From: Anita Gardner
Sent: 08 February 2022 09:22
To: [REDACTED]
Subject: FW: Planning Consultation on: CM/4/22/DOC

Engineers Comments Regarding Condition 8

Application No: CM/4/22/DOC

Description of Works: Approval of details reserved by condition imposed under ref CM/64/19/PL relating to Condition Nos 8 - as-built drawings and 14 - energy efficiency.

As-built Survey

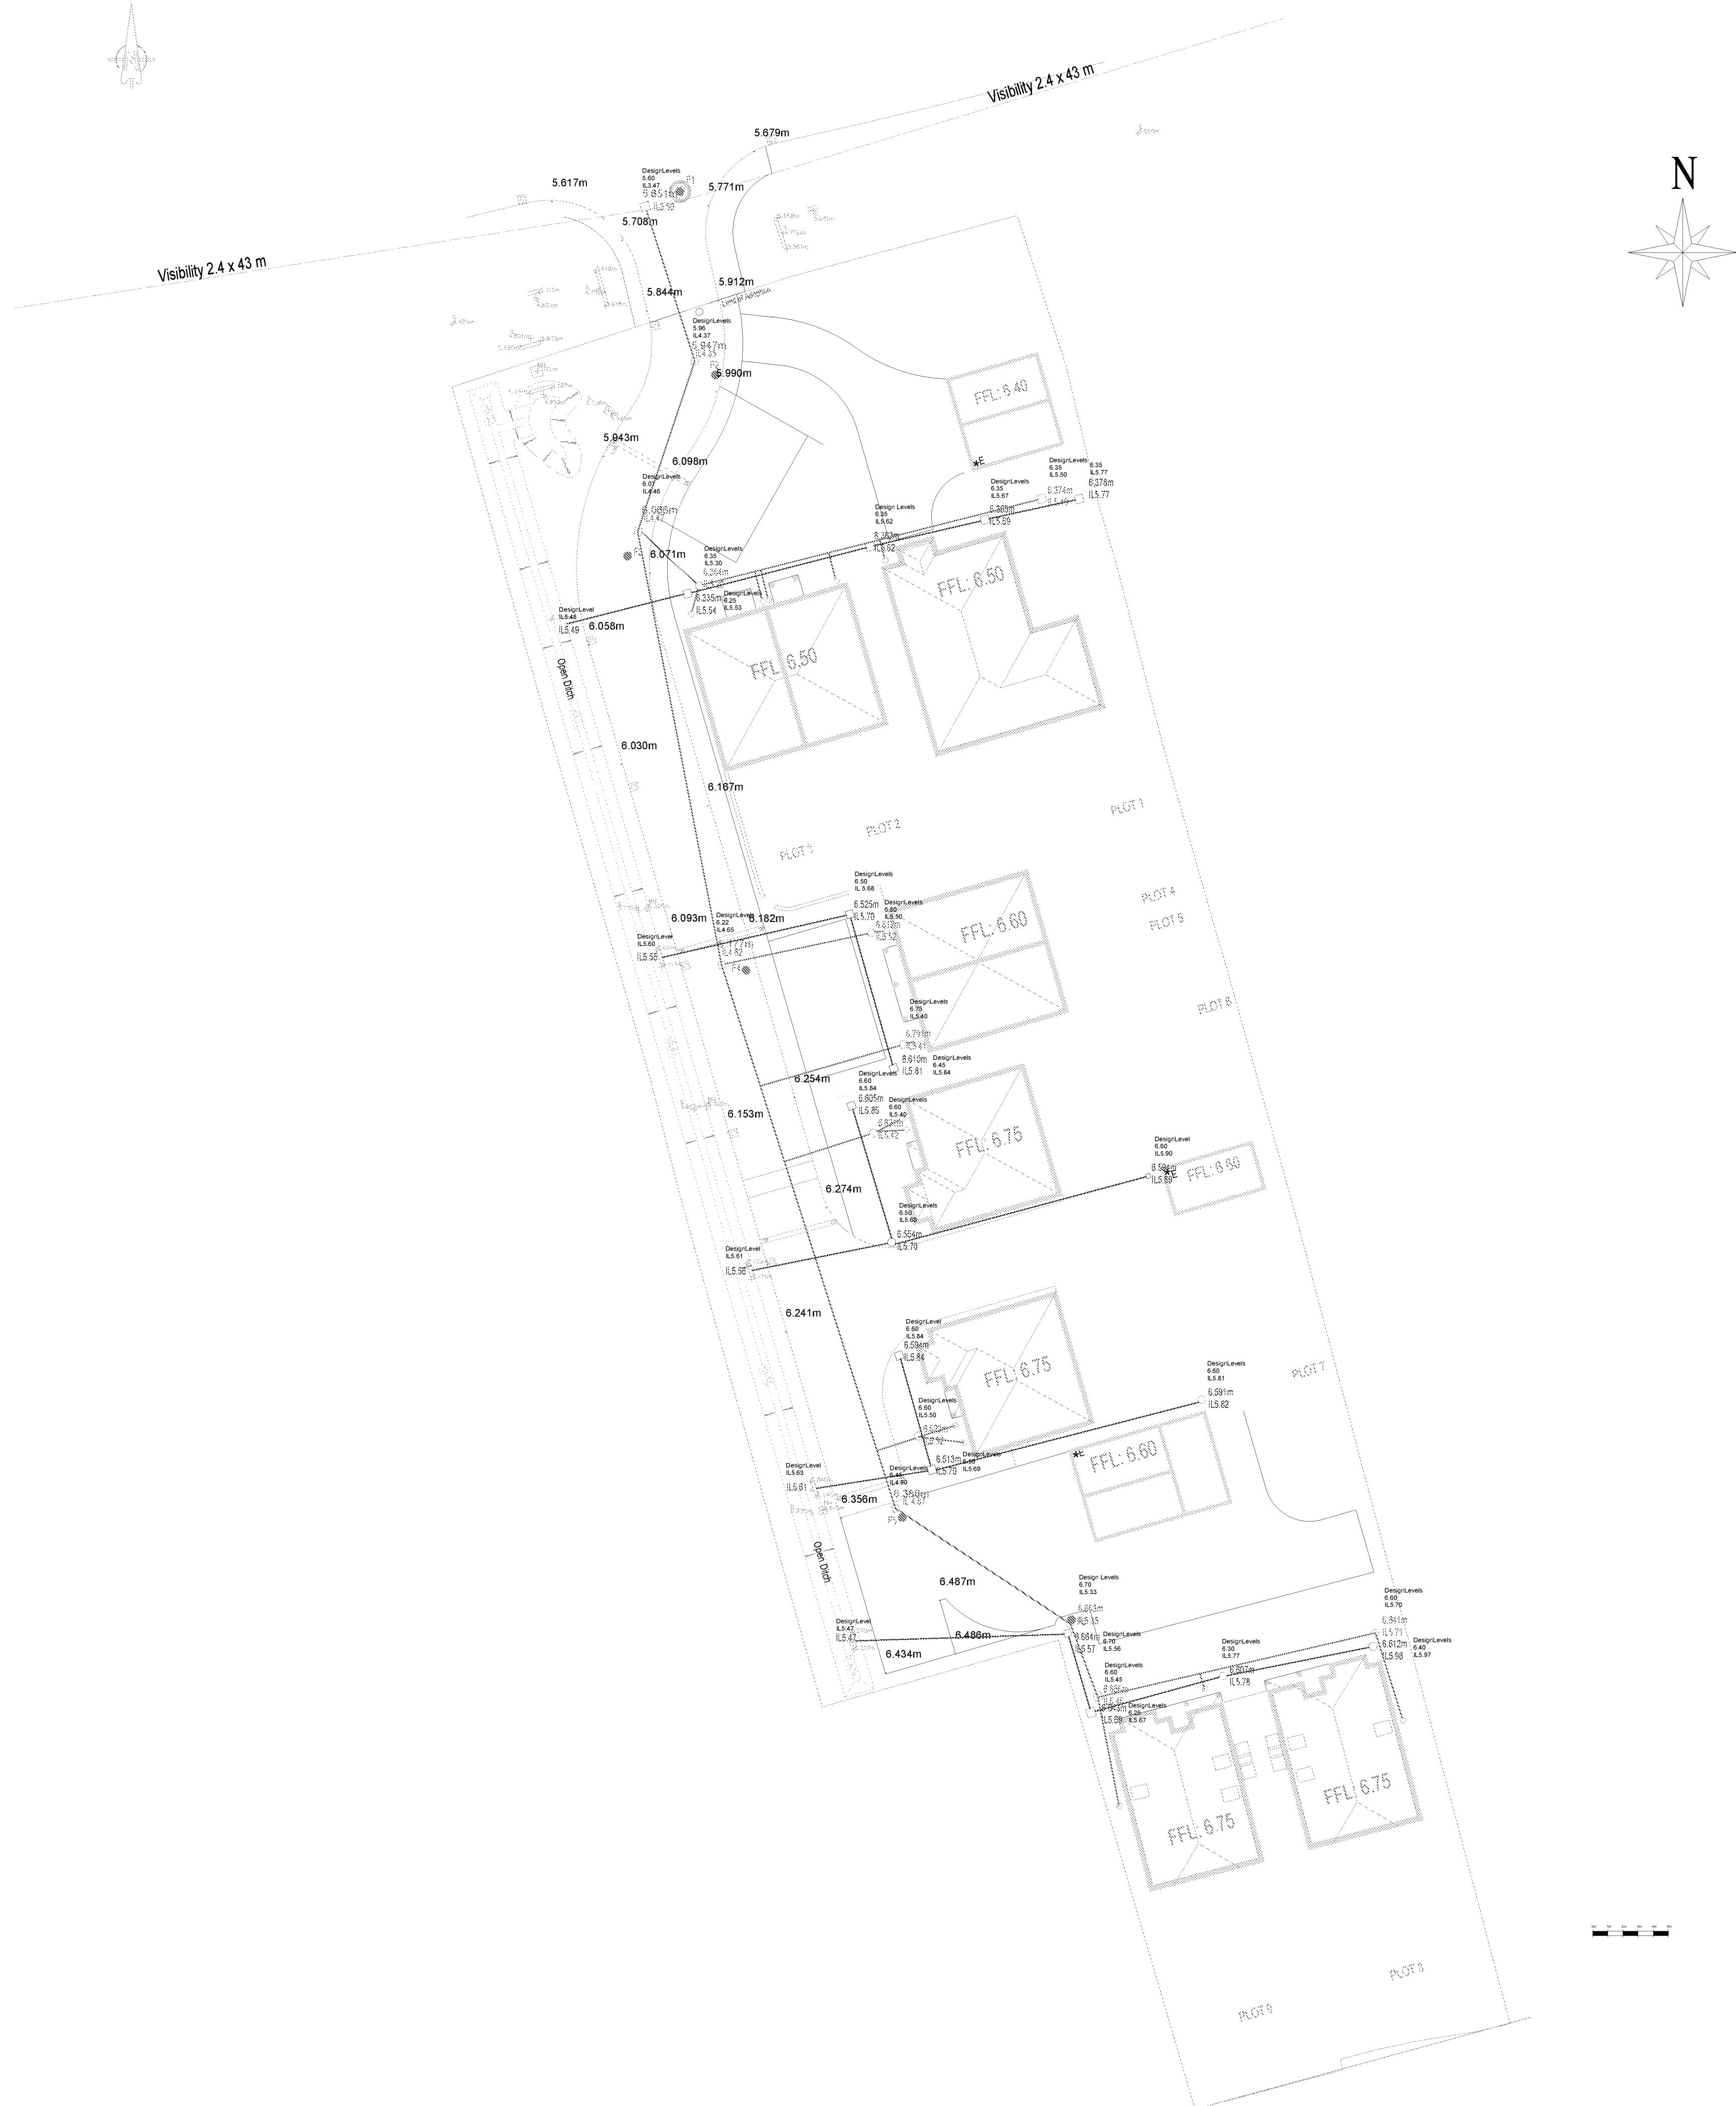
Please provide details of the inspection and verification of control chambers. I.e. surveyed invert and cover levels and good receipts for flow control devices.
